**From:** Maria Tomalova  
**Sent:** Tuesday, September 28, 2021 3:09 PM  
**To:** Ellie White [REDACTED]  
**Subject:** Stakers Farm, Y/107/21/PL, Y/108/21/L

Stakers Farm North End Road Yapton BN18 0DU

Listed building consent for conversion of & alterations to existing barns to create 3 No. dwellings, erection of car barns & stores, a replacement pump house, demolition of barn, associated landscaping & parking (amendment to Y/106/19/L)

DRAWING TITLE
BARNs - SITE LOCATION PLAN AND
BLOCK PLAN

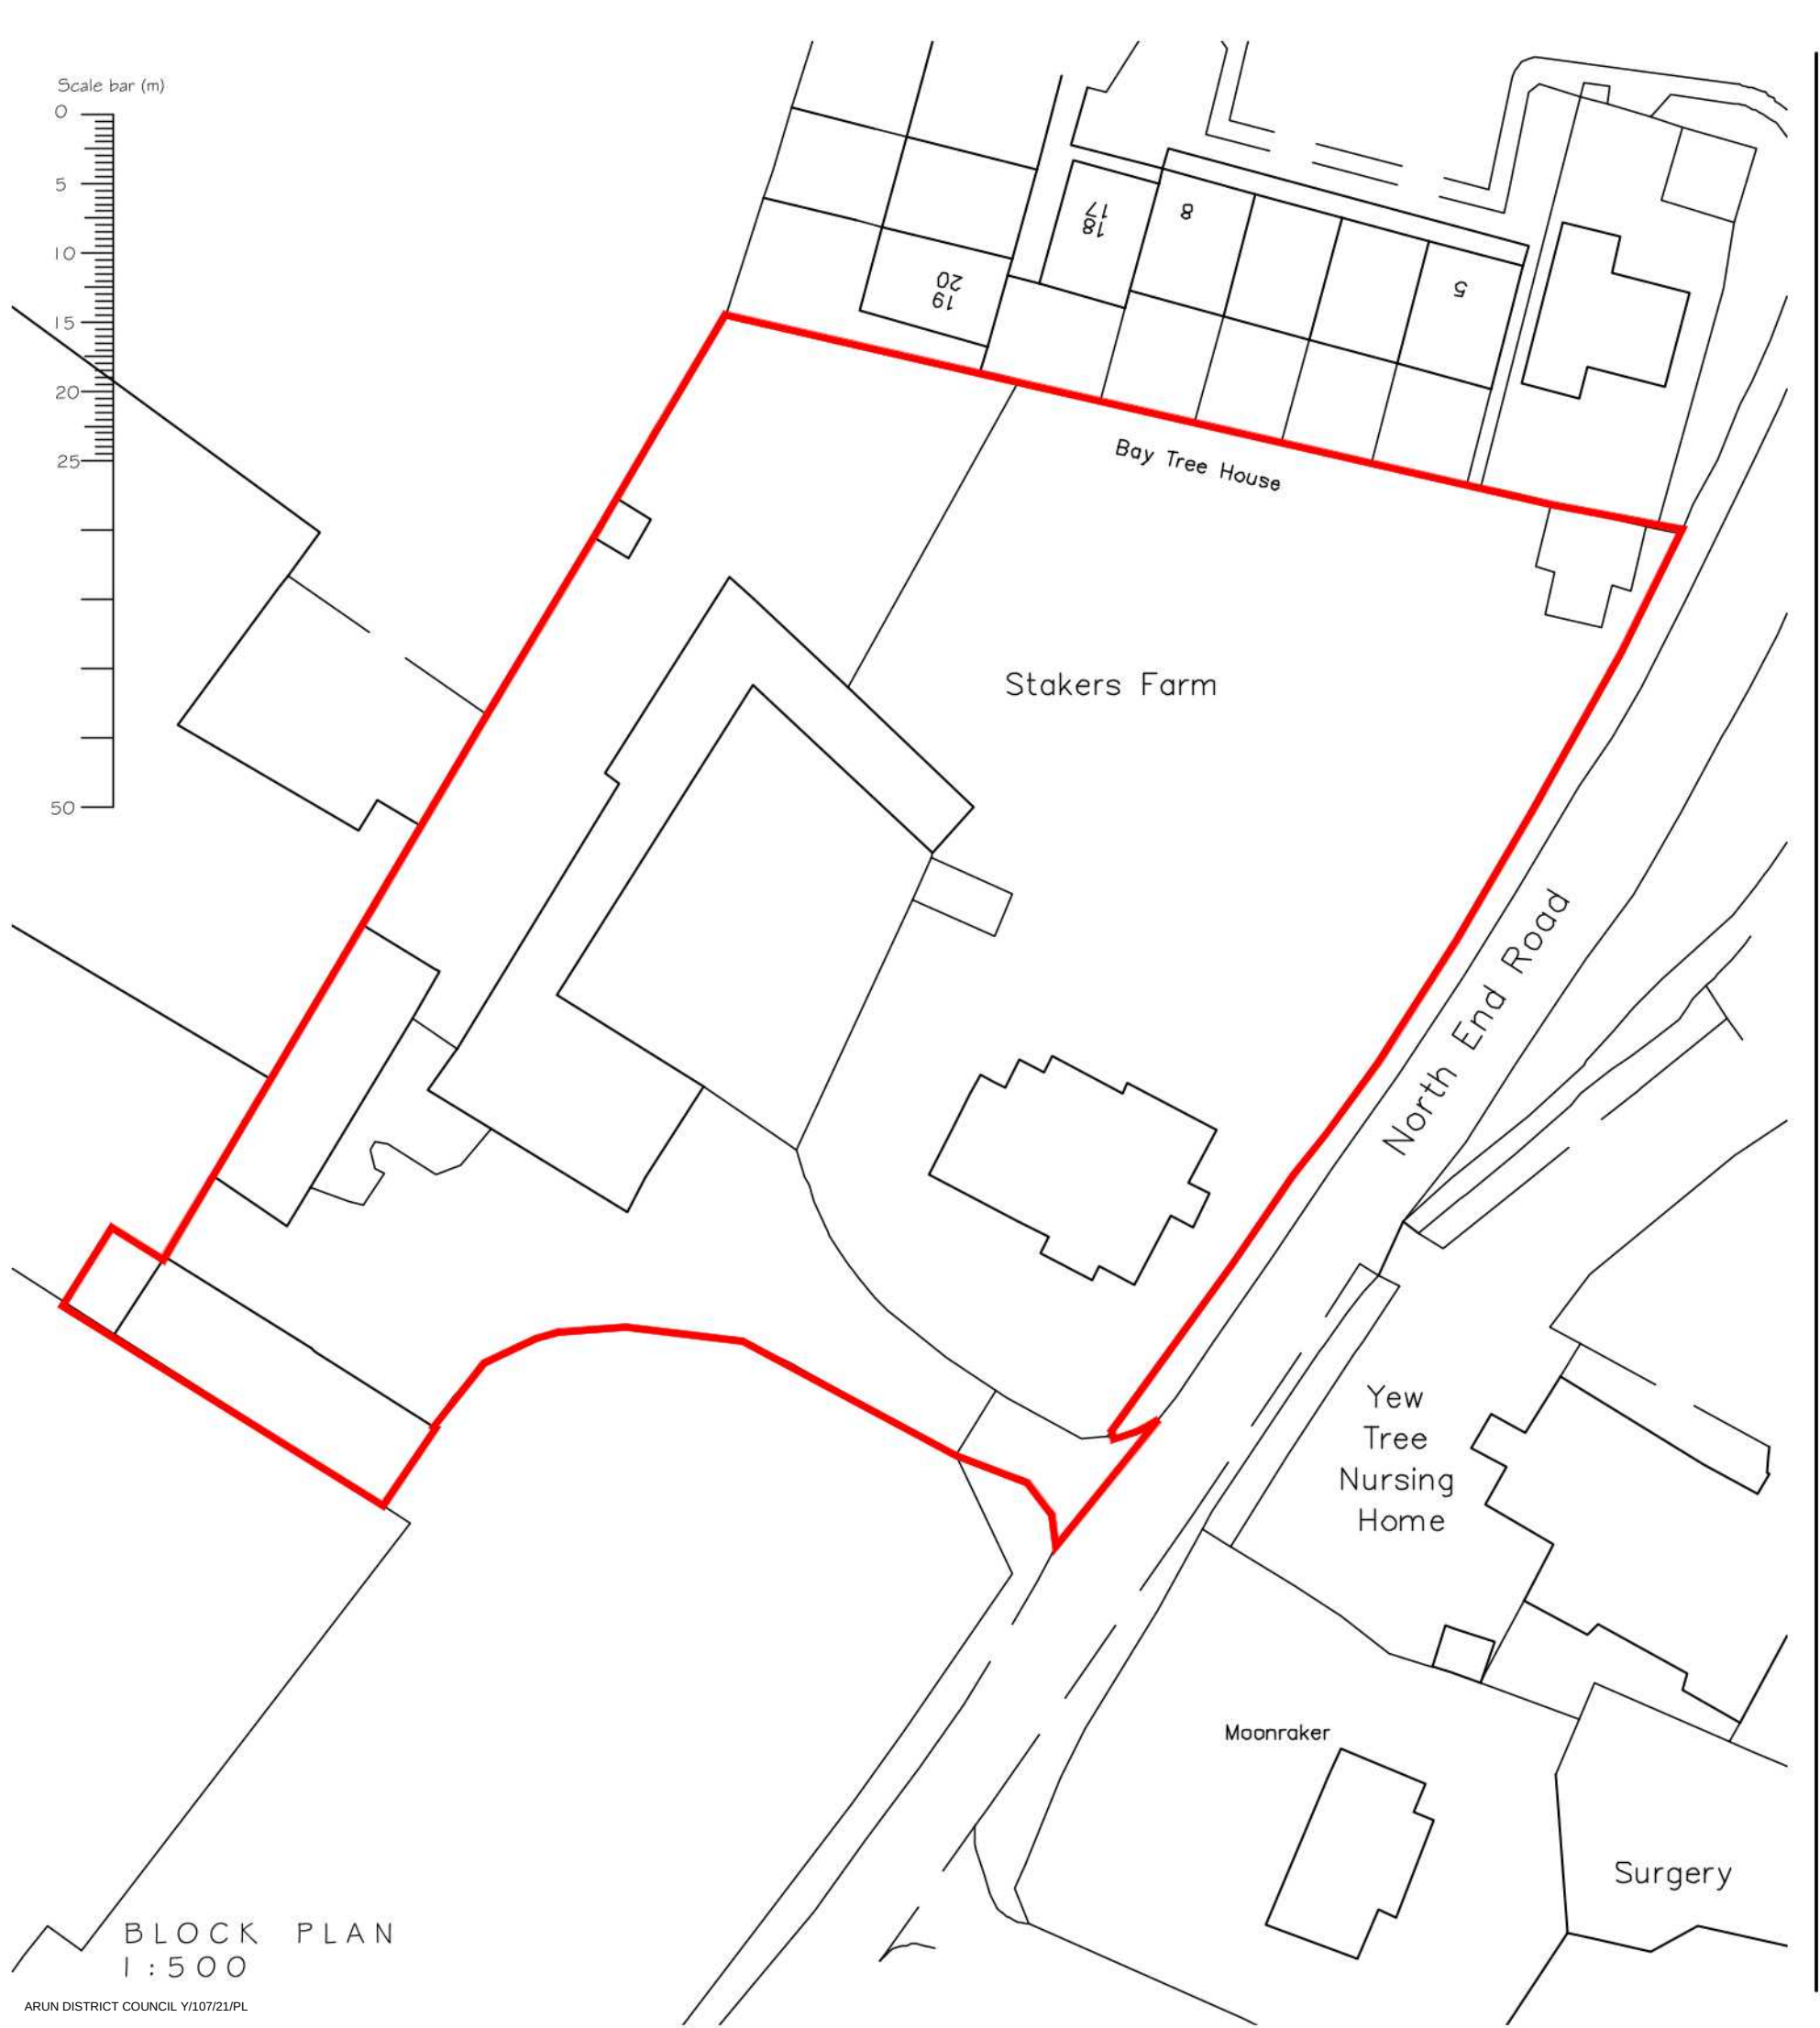
The use of brick paviours is of some concern, as this could introduce a sub-urban character into what should be a more rural one. From looking at the site plan it would appear that a significant area of the site would be paved in order to provide access to the parking courtyard. It is not clear why such a material was chosen, when something more in keeping would be more appropriate. However, if carefully chosen, it could be that such an approach would be acceptable. A sample of the material would be requested so as to fully assess the impact.

DRAWING TITLE
PROPOSED BIN STORES AND GARAGING / BIKE STORES FOR BARN 1

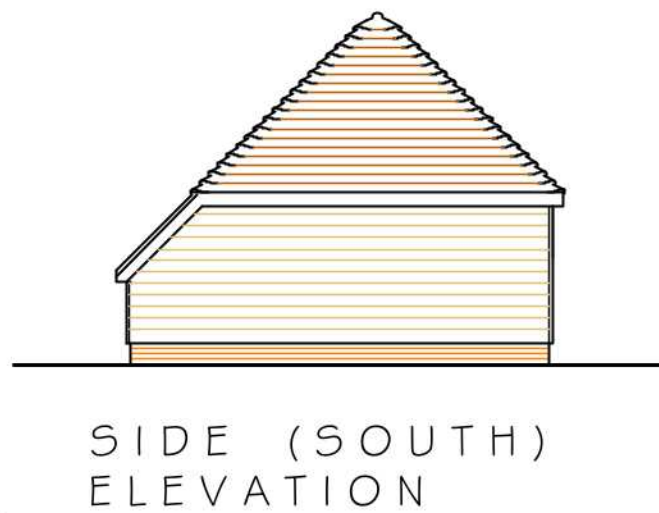
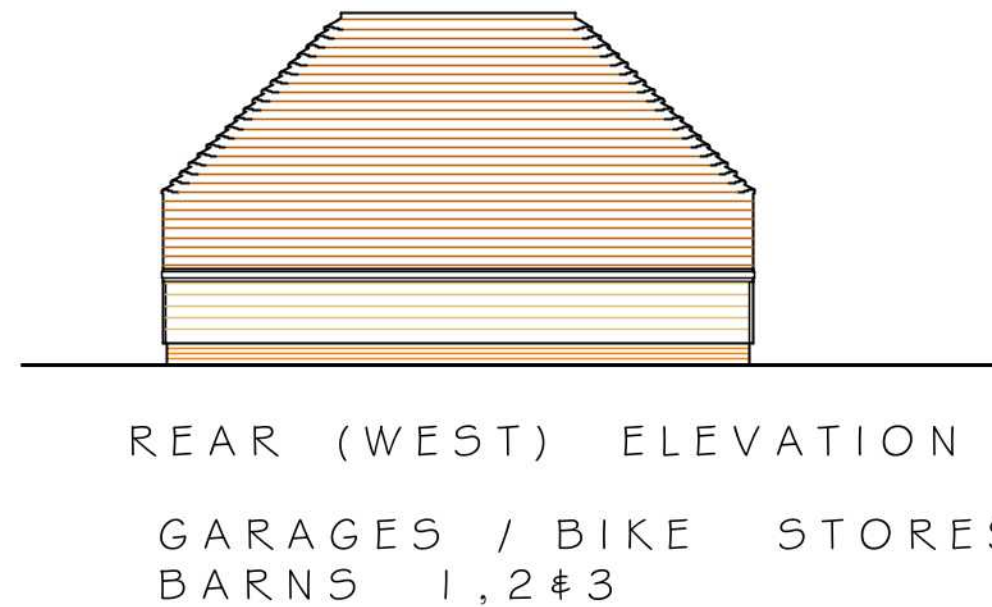
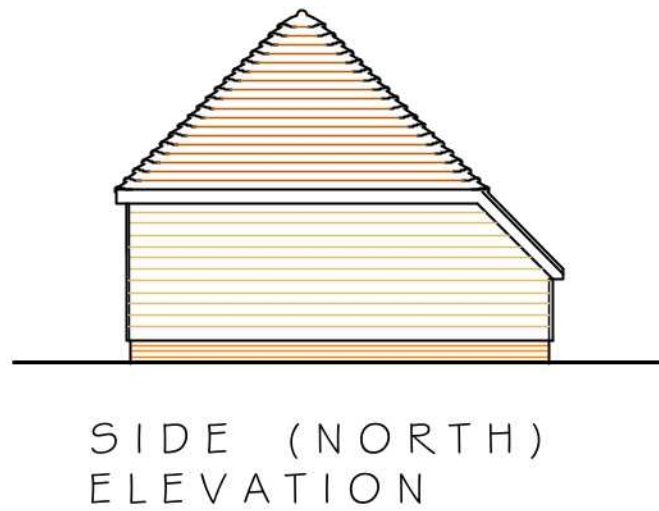
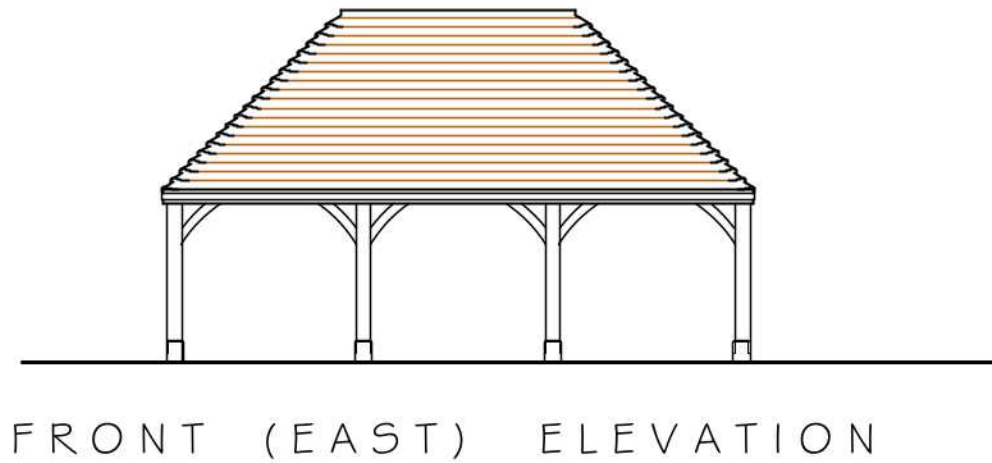
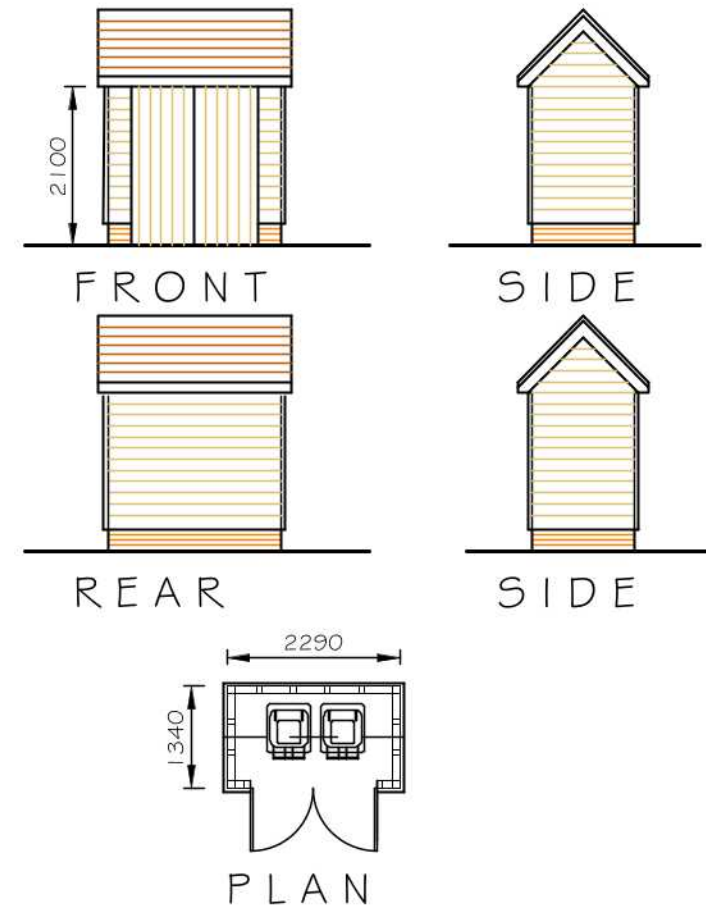
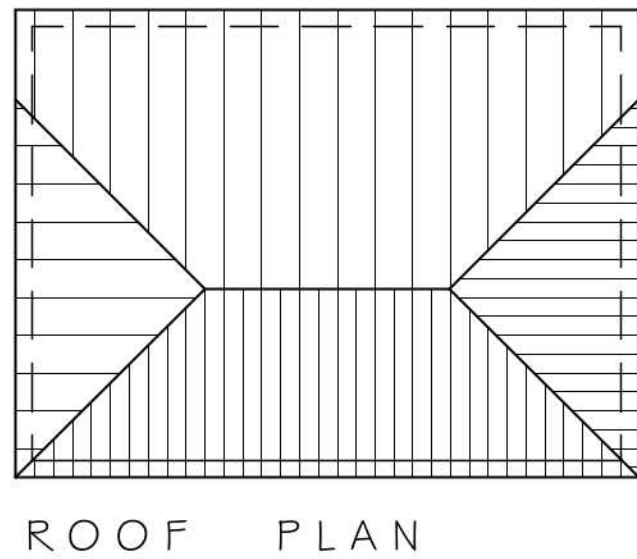
are not to be incorporated as part of the final scheme. This is disappointing, as they retain character as part of the building, and are reminders of previous use. Where doors remain, they can be retained and used as shutters; doors can be fixed open in order to ensure that enough light is available to the interior of the building. If in a poor state of repair, they can be repaired or replicated, or if missing, new ones can be made. This approach was used on the previous applications and it is not clear why it cannot be followed here as well.
